With reference to application **LU/181/20/HH**, we would like to lodge our formal objections as listed below with further comments beneath:

| <b>Plans and elevations as proposed</b>                                             |                   |

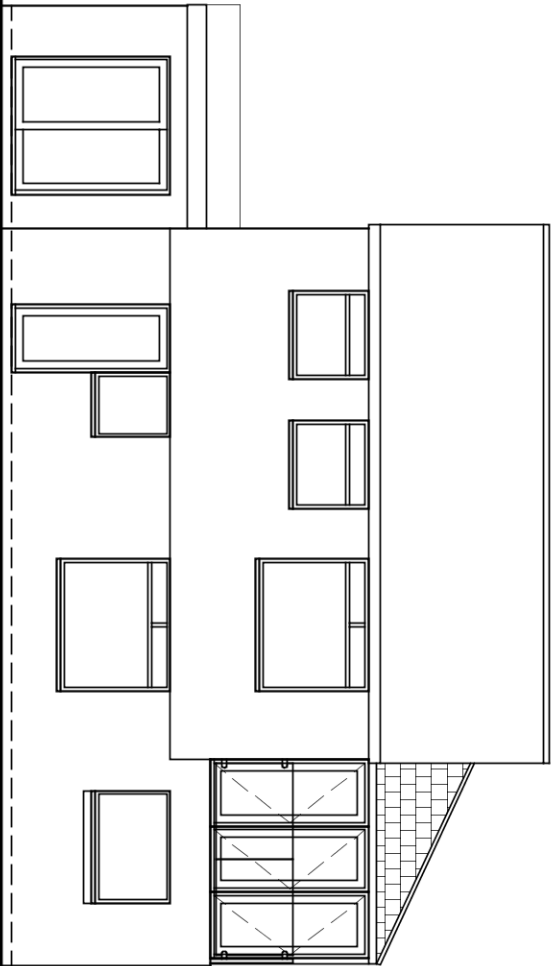
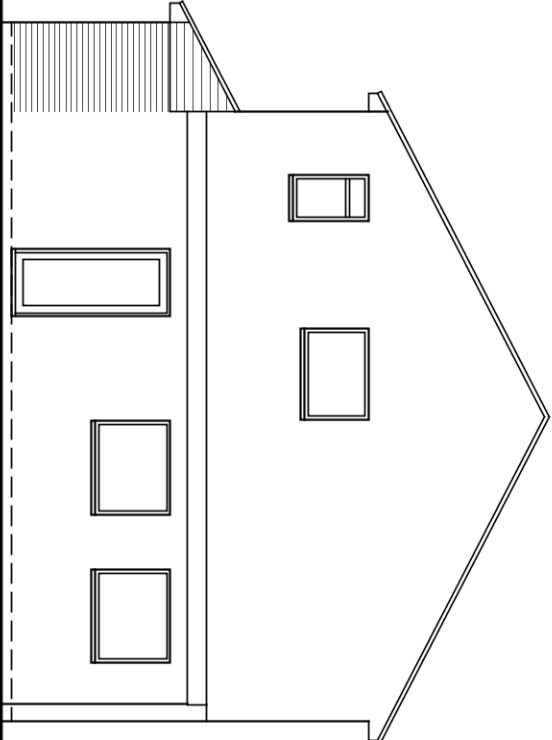
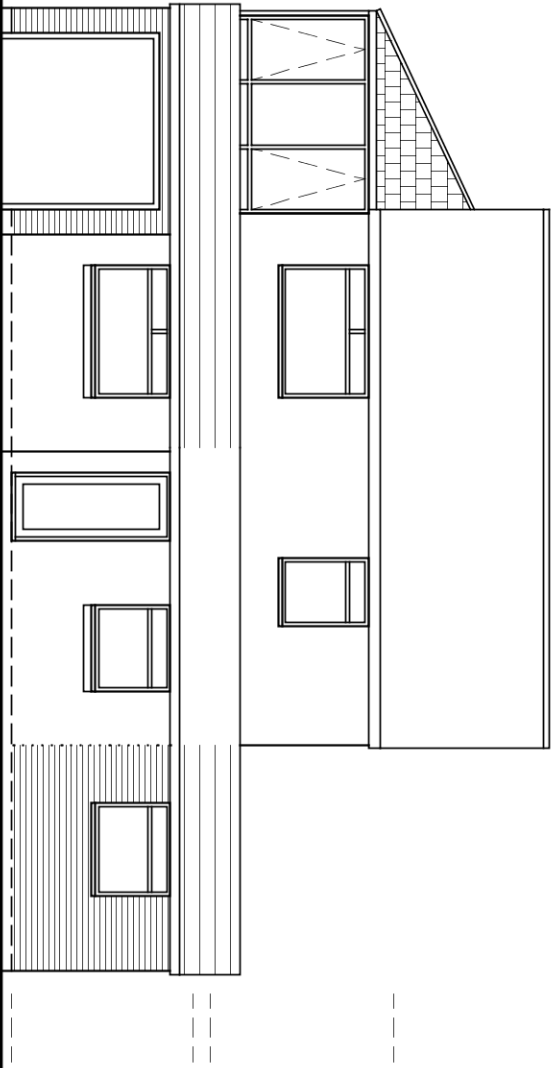
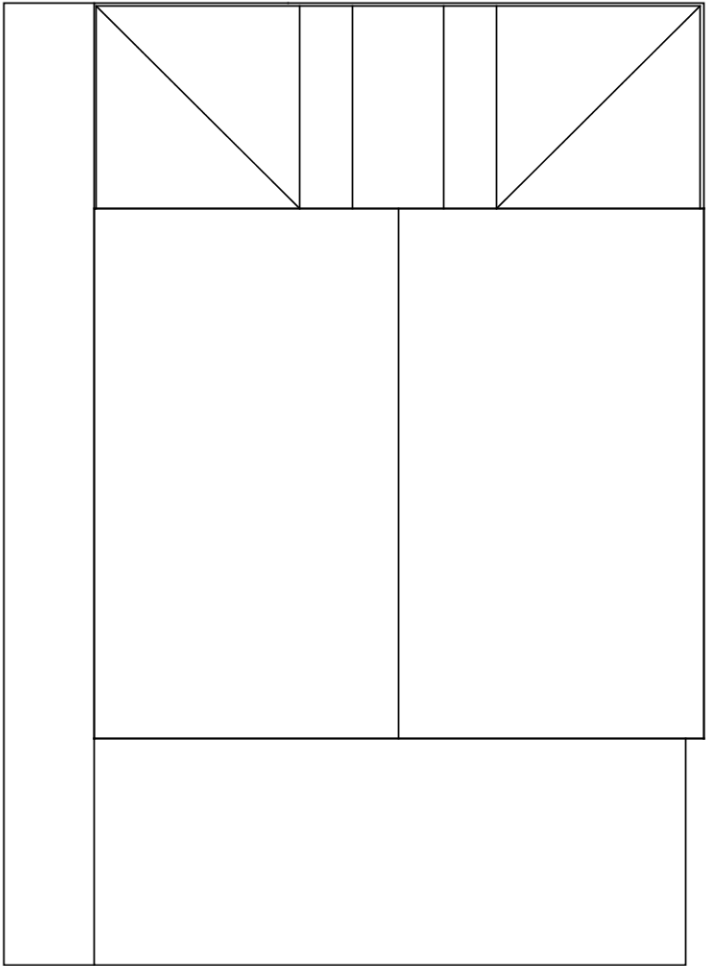
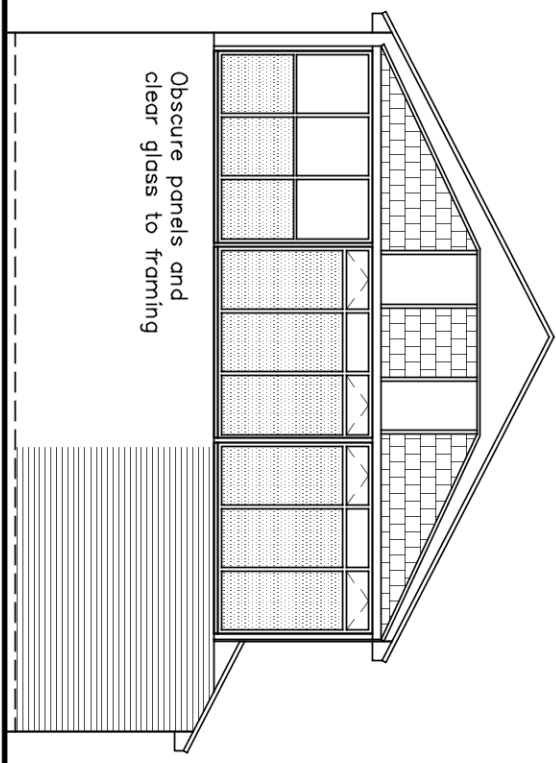
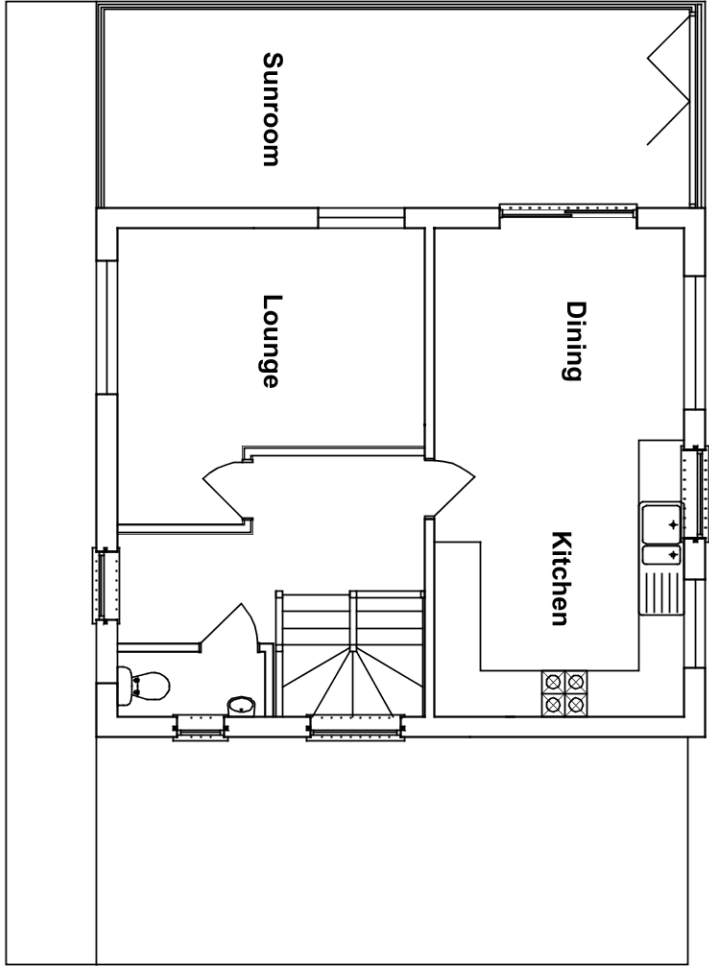
1. Overlooking and loss of privacy
 - a. Although there is an existing balcony, it is not covered and therefore not generally available for use every hour of every day. The proposed 'sun lounge' creates a habitable space (however it is described) which will be in regular use *every day*. From the windows of the sun lounge, there will be a clear, unobstructed view directly through our landing window which will lead to a considerable loss of privacy. In addition, our garden and patio area will be completely overlooked where now there is considerable privacy. It is worth noting that, whilst all the properties here have balconies to the East side, most home-owners have arranged patio areas to the East of their gardens to afford a degree of privacy. If approved, the sun-lounge will have direct views into that area.

2. Loss of natural light
 - a. If approved, the uPVC structure on top of the existing garage would, in effect, create a two-story wall less than 1.8m from our property where there is currently a single-story wall. This will severely restrict natural light entering through our glazed kitchen door, landing window and downstairs WC. Please see attached *Plan1.pdf* which shows relative positions of our windows. The loss of light through the landing and WC windows and kitchen door will be considerable.

- b. Access to our rear garden is via a passageway at the West side of the property. If approved, the planned extension to the front will create a long, dark, and oppressive walkway where there is now open space and natural light. Property layout has been designed with a staggered frontage so as to afford privacy and natural light to each neighbouring property. This application, if approved, will defeat that feature.

3. Visual impact / out of character
 - a. This property, along with ours, backs onto the pitch & putt golf course and is clearly visible from both the golf course and sea-front promenade. The plans describe what is effectively a large conservatory built atop the existing garage which will look very out of place, be entirely out of character and detrimental to the appearance of what is now an attractive area. We are also concerned that, if approved, a precedent may be set which could

4. Design & materials
 - a. Although the planned extension to the North (front) is of brick construction, the sun-room is of uPVC. The construction will therefore not be in keeping with the rest of the property nor neighbouring properties and will be visually unattractive
